WEST SUSSEX COUNTY COUNCIL CONSULTATION

TO:	Arun District Council FAO: Leanne Richardson
FROM:	WSCC – Highway Authority
DATE:	19 September 2024
LOCATION:	Land at Woodgate Nurseries Lidsey Road Woodgate
SUBJECT:	AL/89/24/OUT Outline planning with all matters reserved (except access) for the demolition of existing redundant nursery buildings and other structures and erection of a residential development of with up to 130 No dwellings, informal and formal public open space, landscaping, drainage, and other associated works. This application may be a Departure from the Development Plan.
DATE OF SITE VISIT:	12 September 2024
RECOMMENDATION:	More Information Required

Pedestrian/Cycle Access (HTp/2401/04/C)

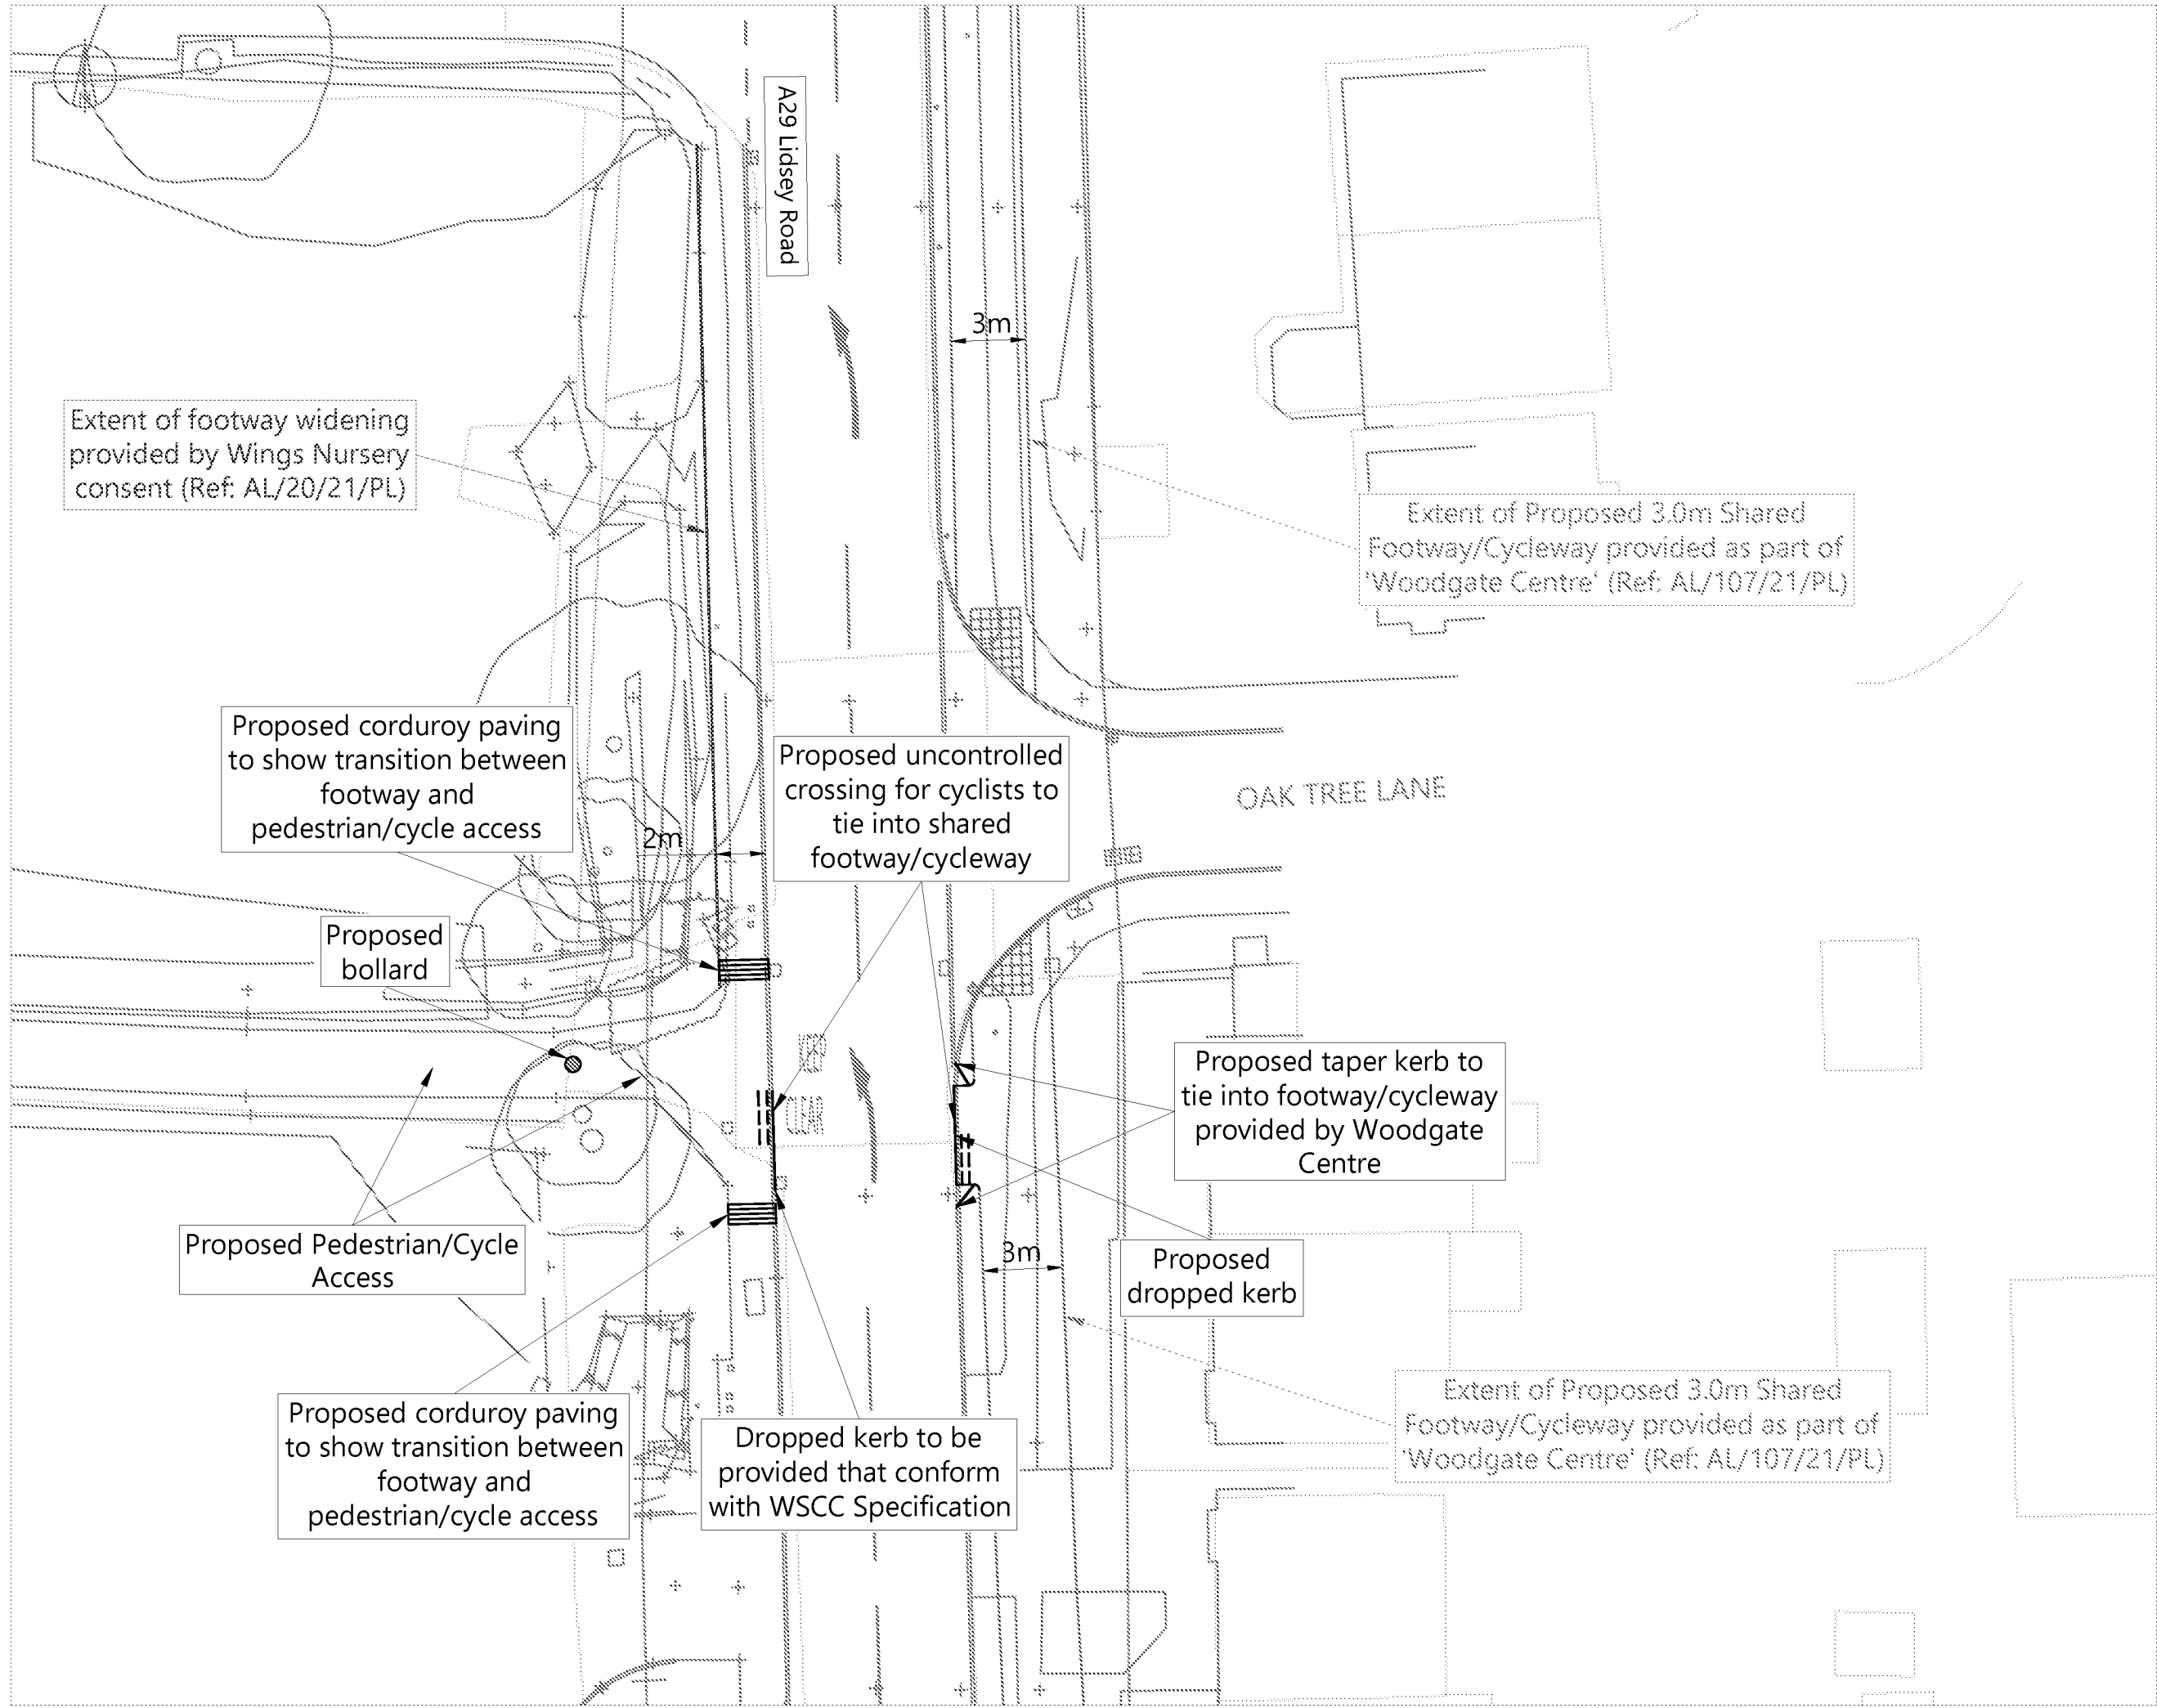
The proposed development, the subject of this current planning application, will result in the access road being closed to vehicular access, instead providing a connection from

the site for pedestrians and cyclists and emergency purposes. However, further detail of this, including its connection with the existing A29 and how such works interface with off-site foot and cycle highway improvements proposed as part of the nearby Woodgate Centre scheme, should be provided.
